ENG-PUDSP20005-R6-PDR-redlines.pdf Markup Summary

INLET ON A CONTINUOUS GRADE

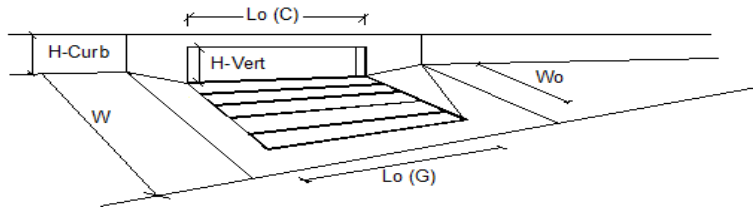
>40 cfs from DP 14 and DP 16 - 24 cfs = 16 cfs?

APPENDIX D
Drainage Maps

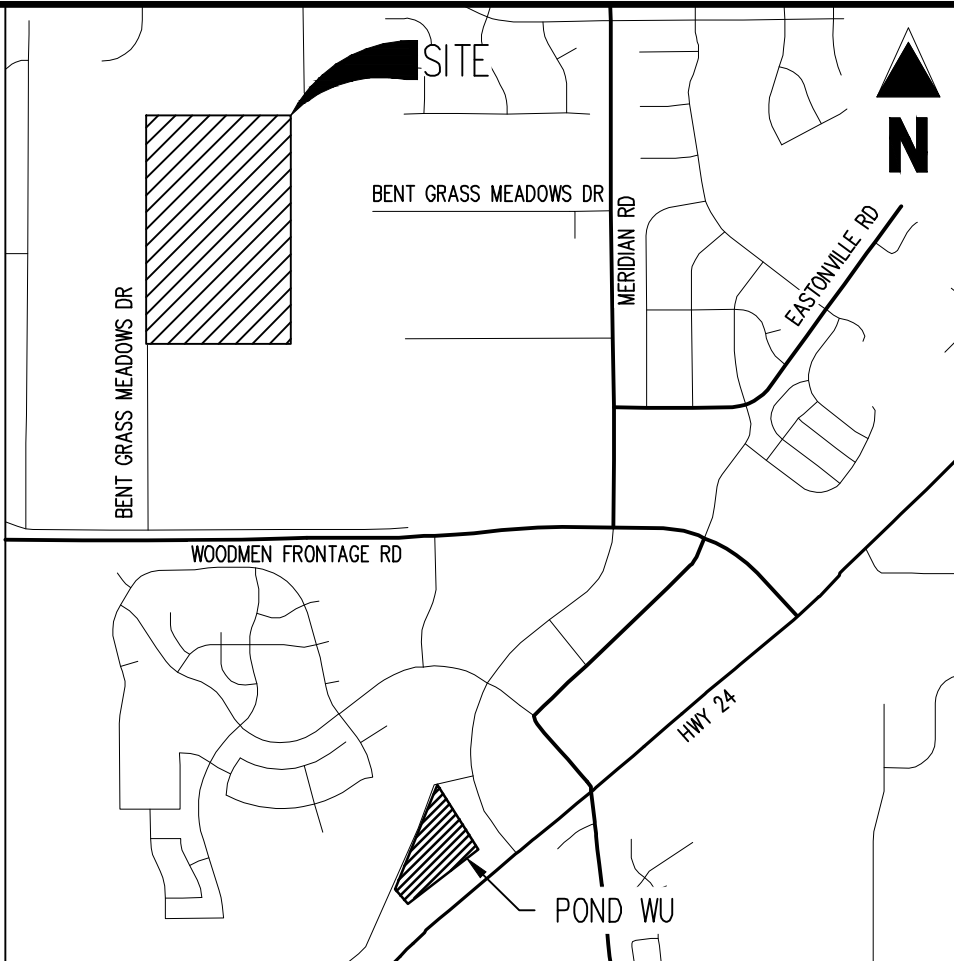
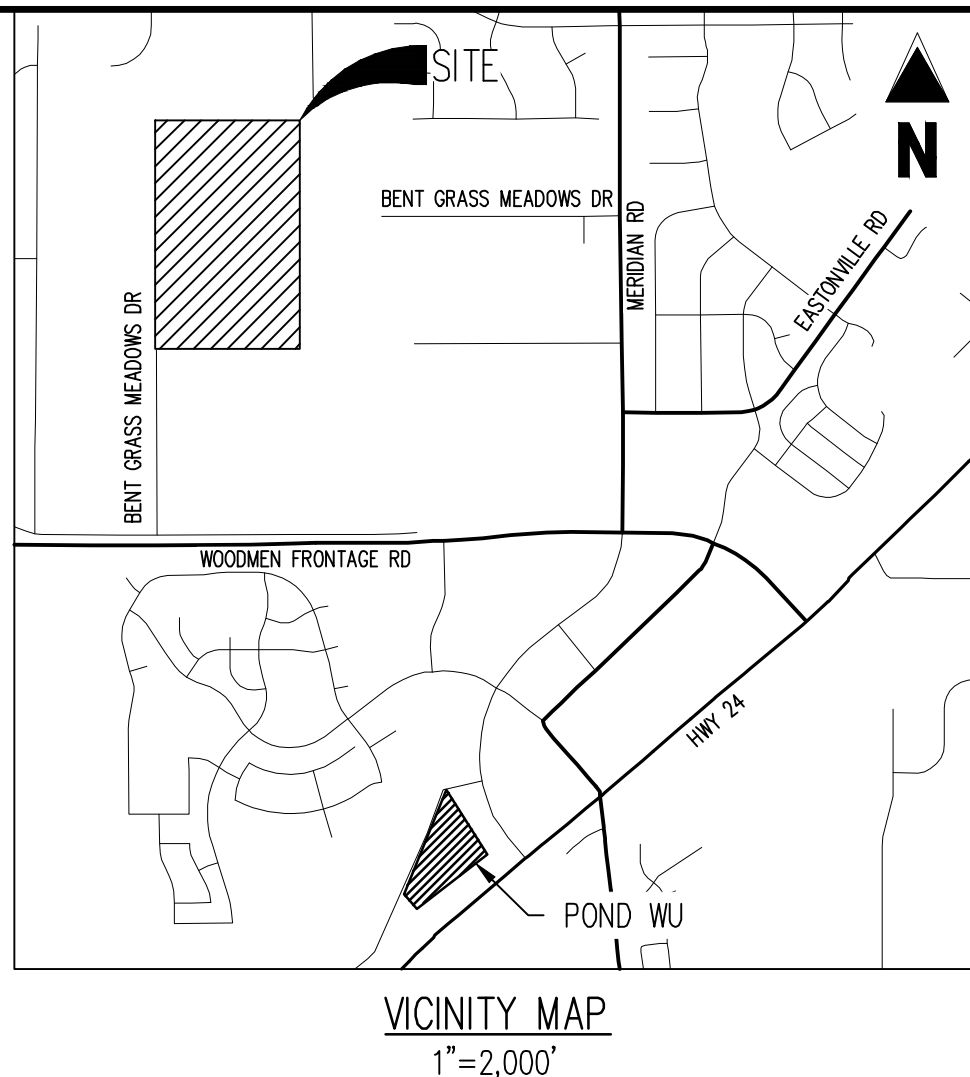
Add DP-21
